From: Renfrow, Brent D (DFW) <Brent.Renfrow@dfw.wa.gov>
Sent: Monday, September 22, 2014 6:26 PM
To: Lindsey Ozbolt; Daniel Valoff (valoffd@ci.ellensburg.wa.us)
Cc: John Marvin; Nelson, Jennifer L (DFW); Harvester, Perry J (DFW); Reed, Catherine D. (ECY); Jeff Watson; Christina Wollman
Subject: Comments Regarding CP-14-00001 & RZ-14-00002 Anderson Hay - Notice of Application
Attachments: AndersonHay-Rezone_comments.ppt

Subject: CP-14-00001 & RZ-14-00002 Anderson Hay - Notice of Application

Anderson Hay Non-Project Rezone (CP-14-00001 & RZ-14-00002)

Anderson Hay and Grain Rezone : Existing Development

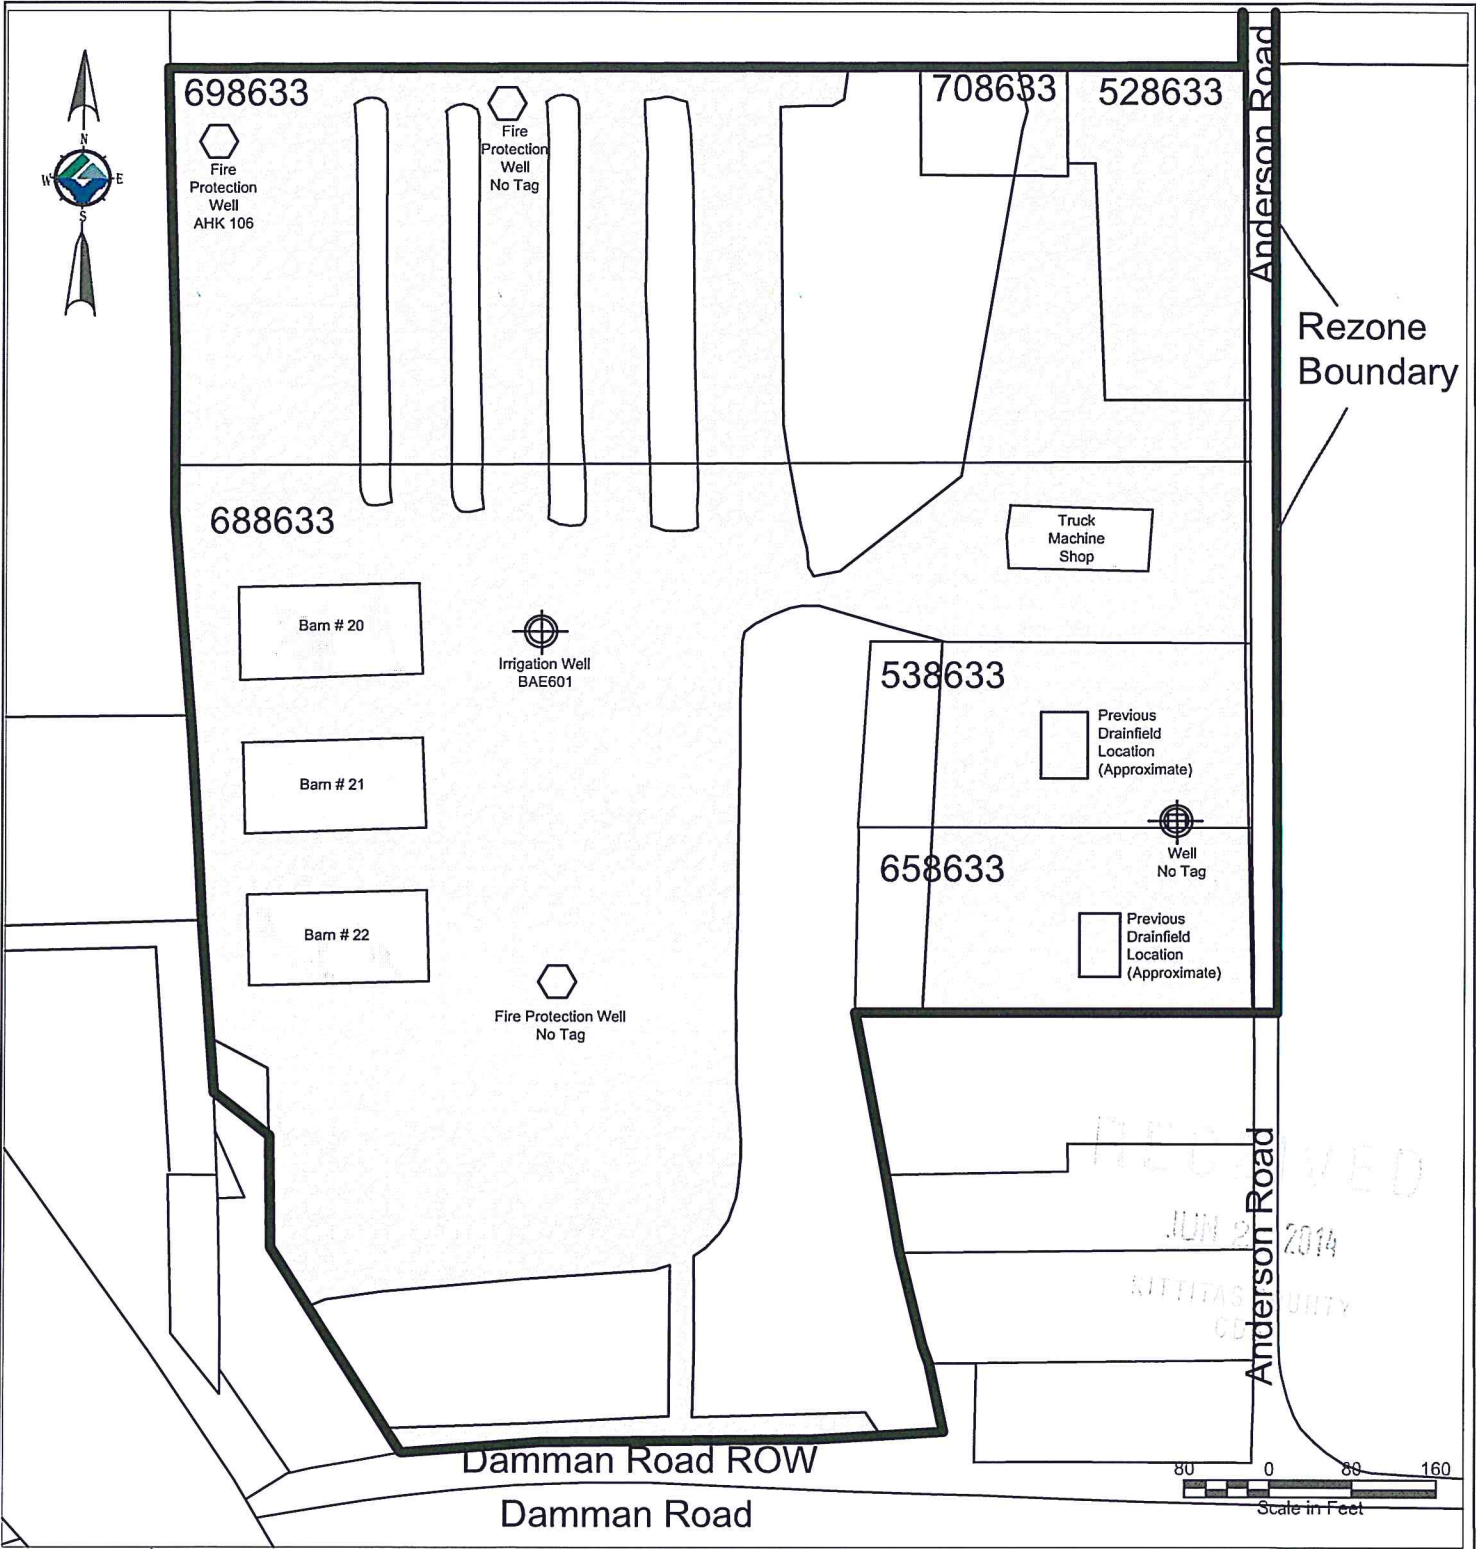
The SEPA checklist for the Anderson Hay rezone project claims that there is no natural watercourse on the subject property. That is incorrect. The property includes a small perennial watercourse, which some refer to as "spring creek" and associated wetlands. This wetland/watercourse joins the Bull Canal adjacent to Umptanum Road and the collective flow of both watercourses then flows into Wilson Creek. In the past I have found fish in the spring creek when the water quality is good. From its confluence with Bull Canal until it flows into Wilson Creek, many species of fish are present including salmon and steelhead, and the rearing of juvenile spring chinook, coho and rainbow trout/steelhead is an important concern. For your reference, I have marked the watercourse/wetland on the attached PowerPoint slides.

This creek location should be recorded on the maps and site plans. The associated wetland should be delineated and an appropriate critical area buffer and structural setback should be assigned for this watercourse/wetland.

All fill necessary for the proposed development should be identified in the SEPA checklist and site plans. Fill should be limited to areas outside of the stream and wetland Critical Area buffers.
